DECISION DELEGATED TO DEVELOPMENT MANAGER

Application No: H11-1007-19 **Applicant:** Mr R White
Proposal: Caravan park reception/office and manager's house
Location: Vicarage Lane Long Sutton Spalding
Terminal Date: 5th June 2020

Proposed Block Plan (1:500)

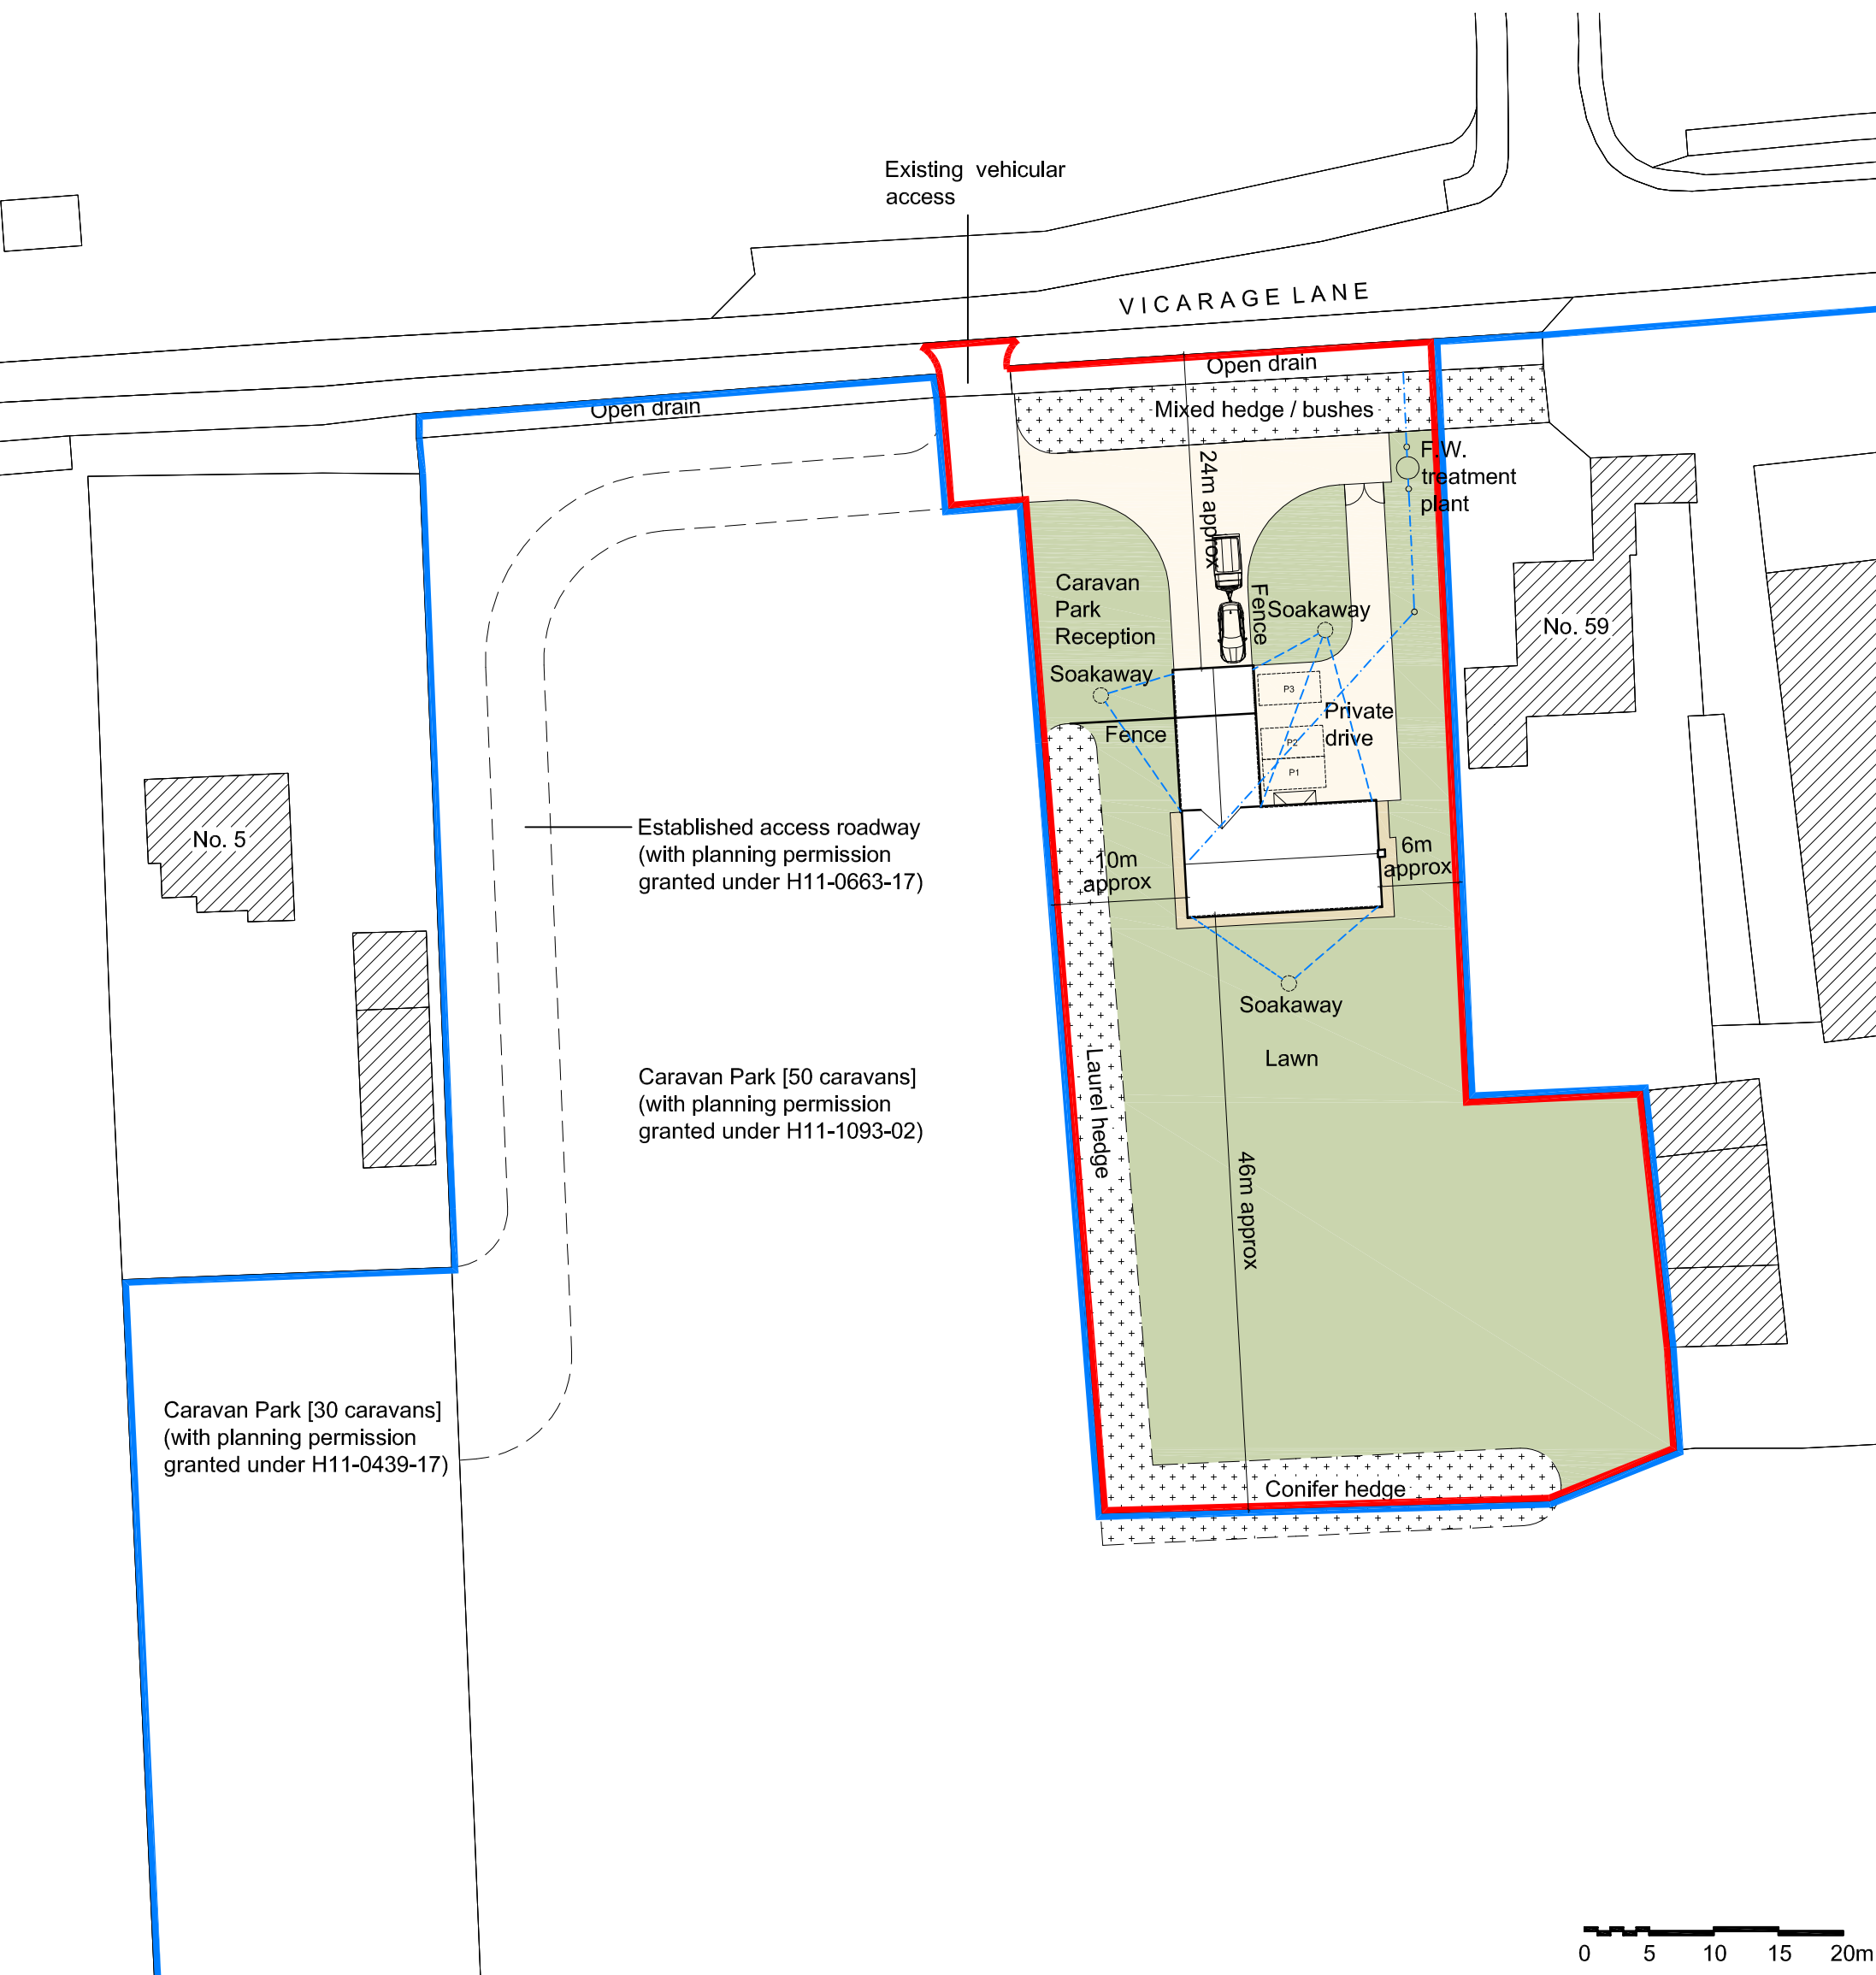
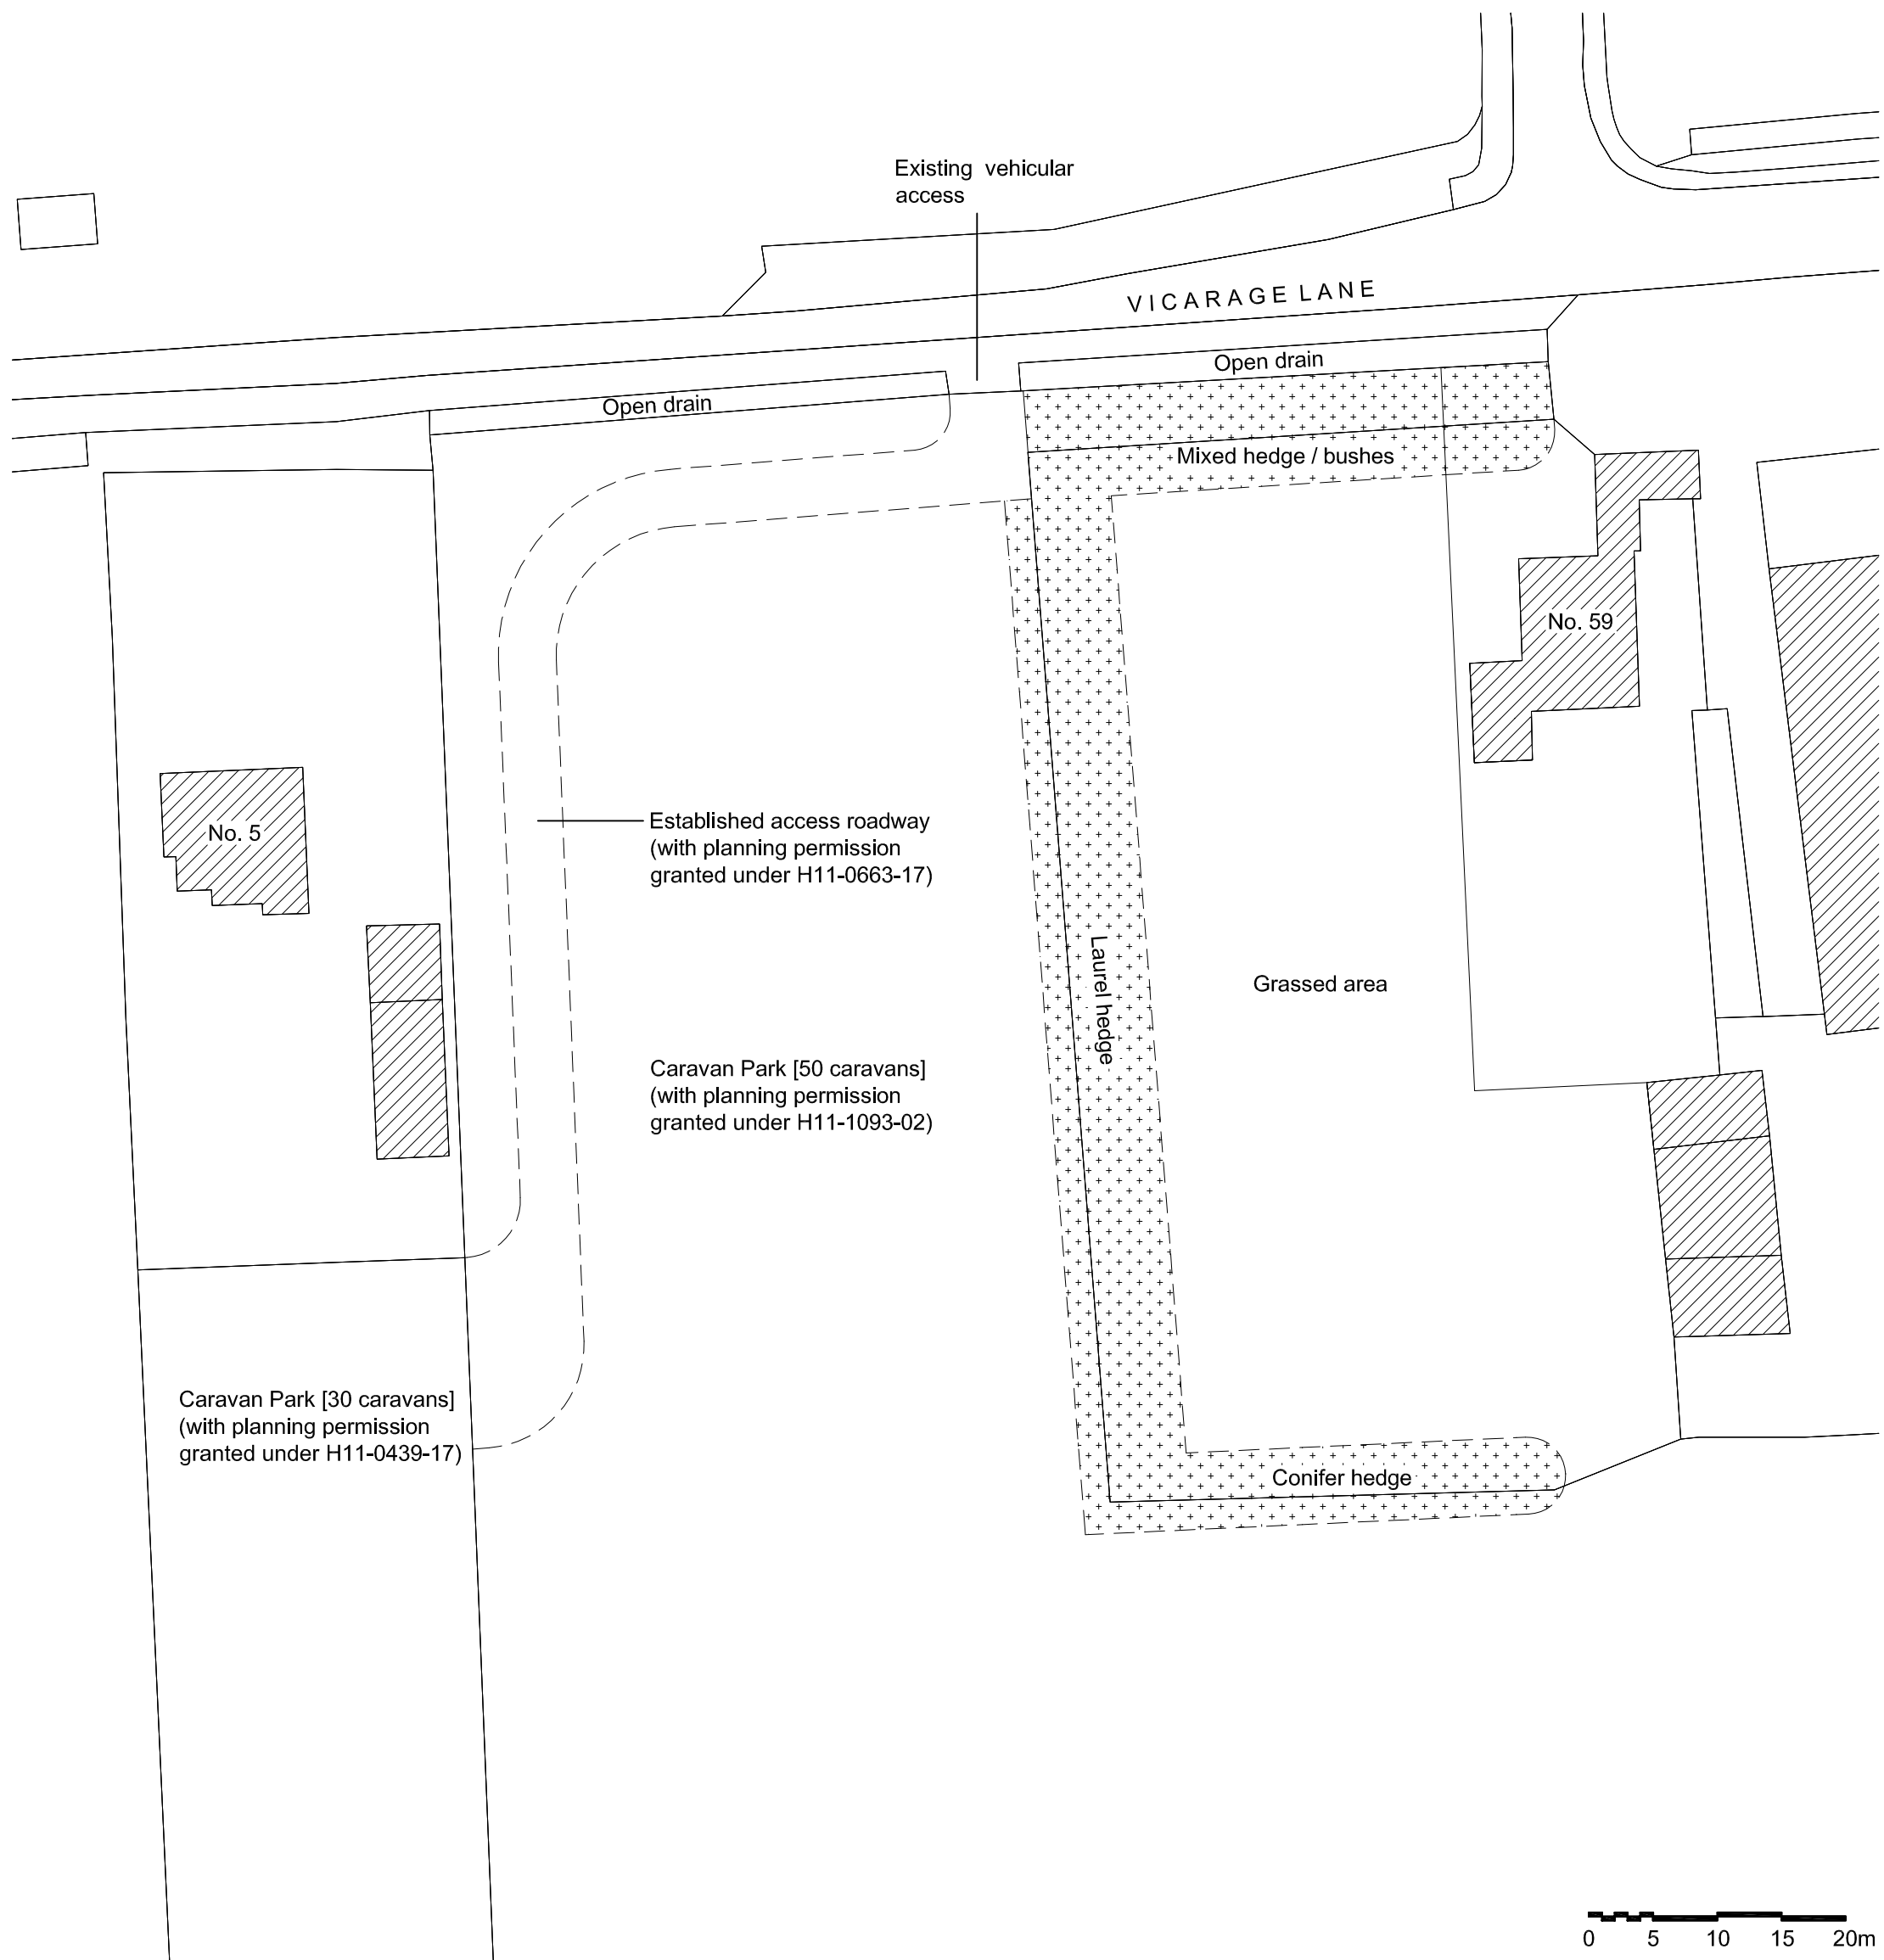
Some concerns were initially raised about the drive layout in terms of highways safety. Revised plans were subsequently submitted and the comments were withdrawn.

There were initial concerns about vehicular movements as visitors would enter the touring caravan site and would turn left towards the caravan park reception/office to book in. It was also raised that no sufficient turning facility was provided to allow vehicles and caravans to continue in to the site to their pitches. A revised block plan was submitted to amend accordingly the drive layout. After that, the County Highways Authority has confirmed no objection against the proposals.
